26 September 2008

**Major Project 06\_0008-Proposed Hotel/Serviced Apartments – Lot 4 DP585556**  
**3 Clyde Street, Batemans Bay**

Pedestrian Network - Proposed Scale 1:5000

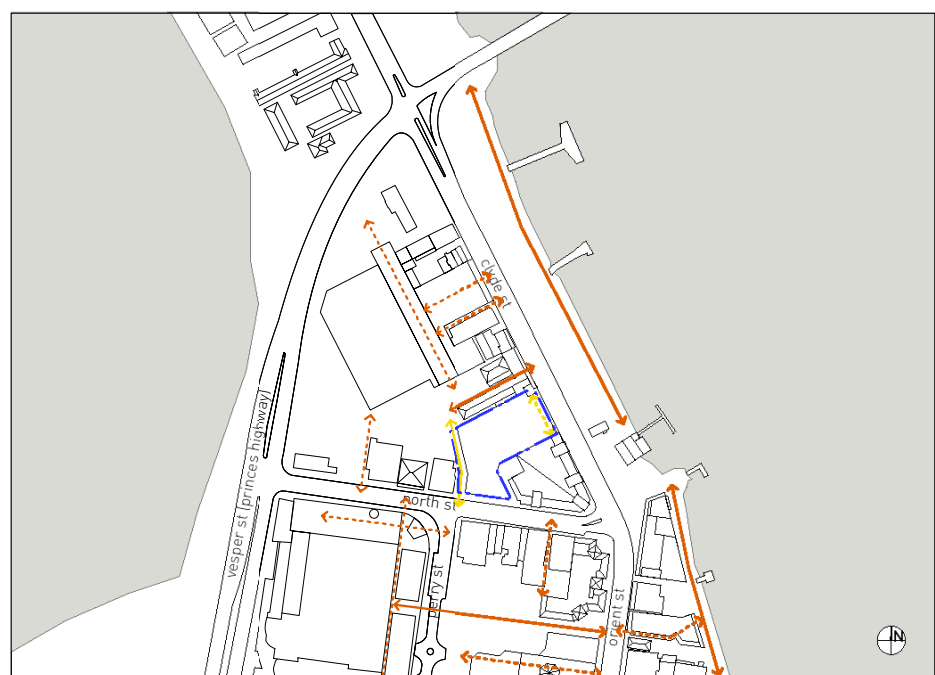
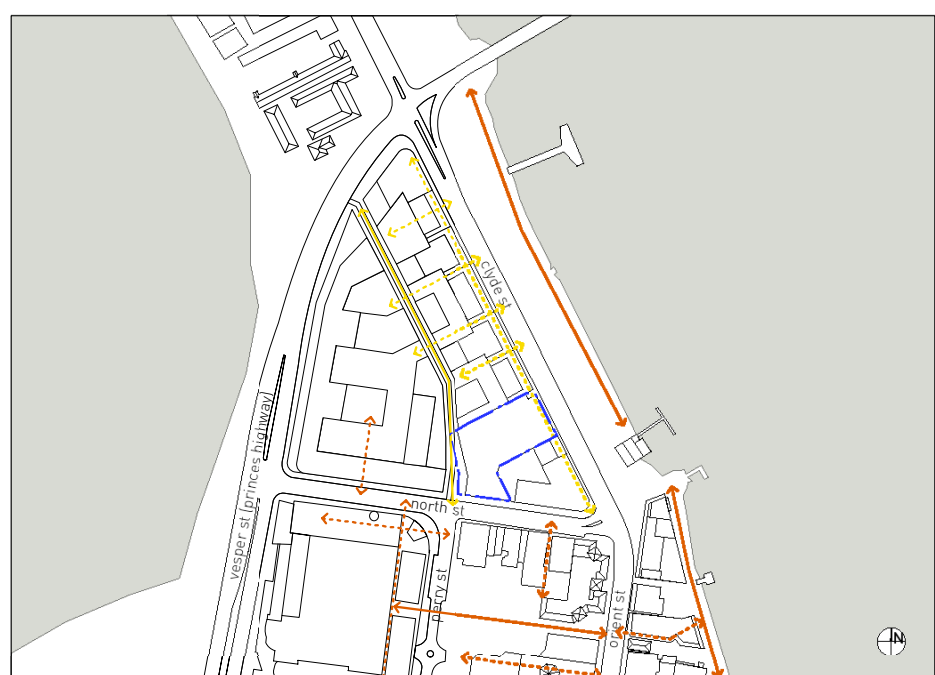
The Centre receives approximately 25% of its foot traffic from North Street via a Council owned footway along the western boundary of the proposed development site. It is proposed to close this footway off for the duration of the development works.

The Council footway is the natural "ant track" for foot traffic between the two major shopping centres in Batemans Bay. Should this avenue be blocked then pedestrians will be forced to take a much more circuitous route further along North Street and then make their way through a heavily trafficked car park. The alternate route would be to walk around the block into Clyde Street – a distance in excess of 250 metres. The withdrawal of this footway will have significant economic impacts on the existing businesses in Bridge Plaza. Loss of sales from diminished foot traffic will also have employment implications for the businesses within the Centre.

We would respectfully ask that this aspect of the proposal be changed to allow the footway to continue to remain open. The hardship and inconvenience that its proposed closure would cause has not been taken into account. It would, in our estimation take every little adjustment on behalf of the developer to accommodate this change.
